About the application

Application number: 2026/90484	
What is the application for?:	Change of use from dwelling to C2 for 4 children, erection of first floor extens
Address of the site or building:	143, Church Lane, Gomersal, Cleckheaton, BD19 4QN
Postcode:	LS27 7HB

Proposed Front Elevation 1:100

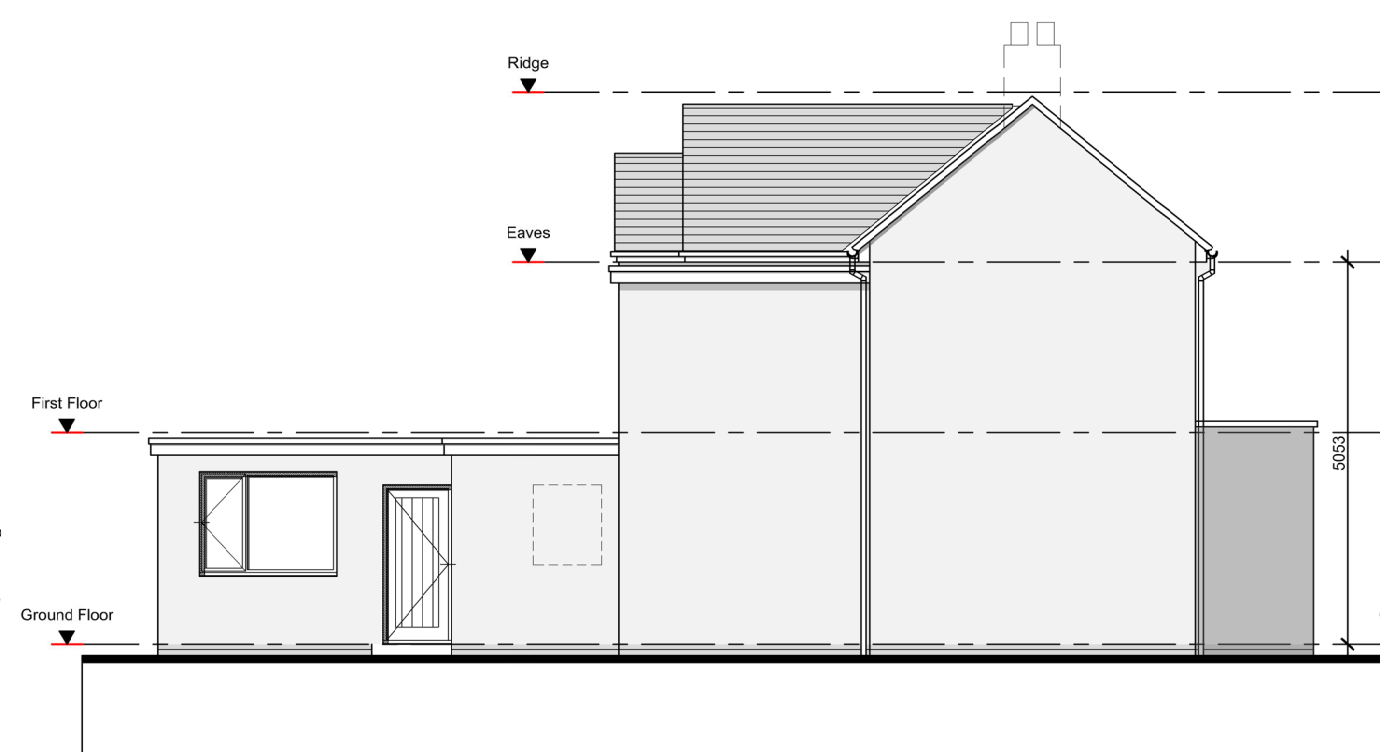
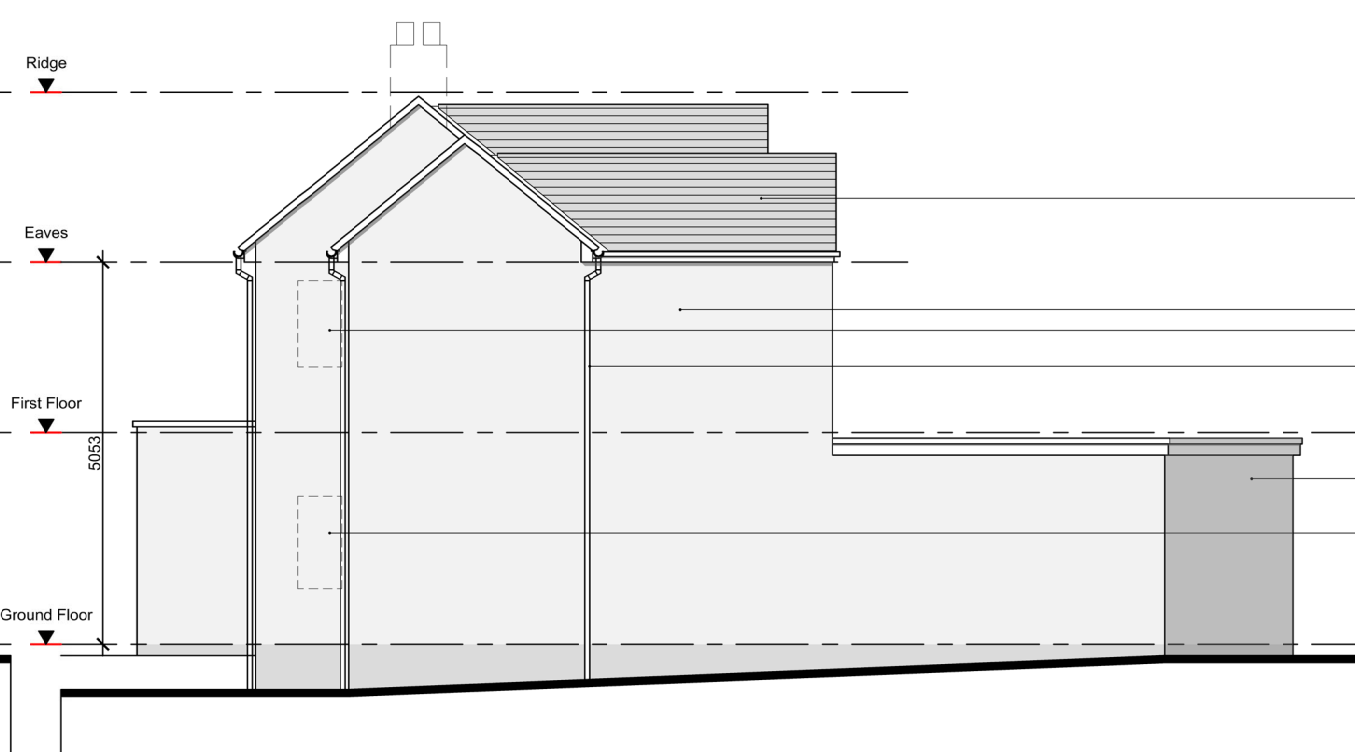
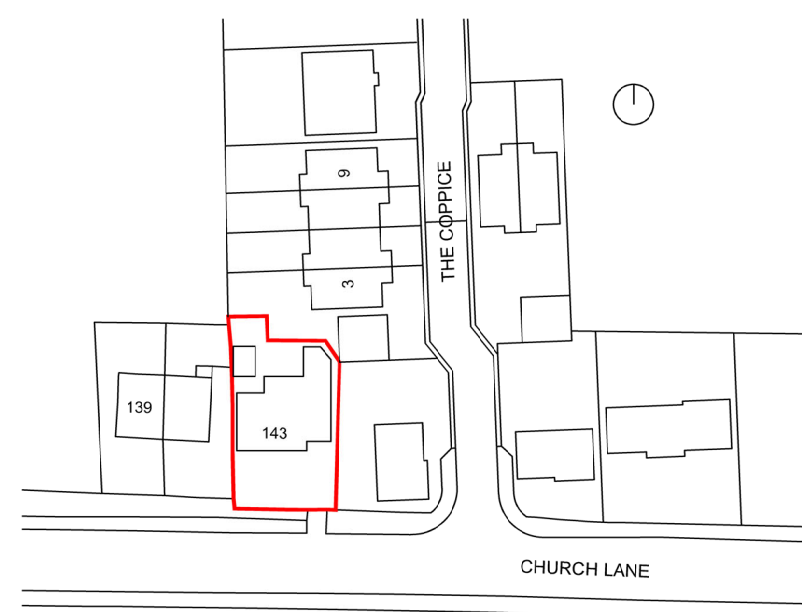
In addition, the proposed first-floor extension raises concerns regarding the scale and visual impact of the development within the existing street scene. Increasing the size and capacity of the property in conjunction with the change of use further intensifies the overall development and may affect neighbouring residential amenity through increased activity and potential overlooking.
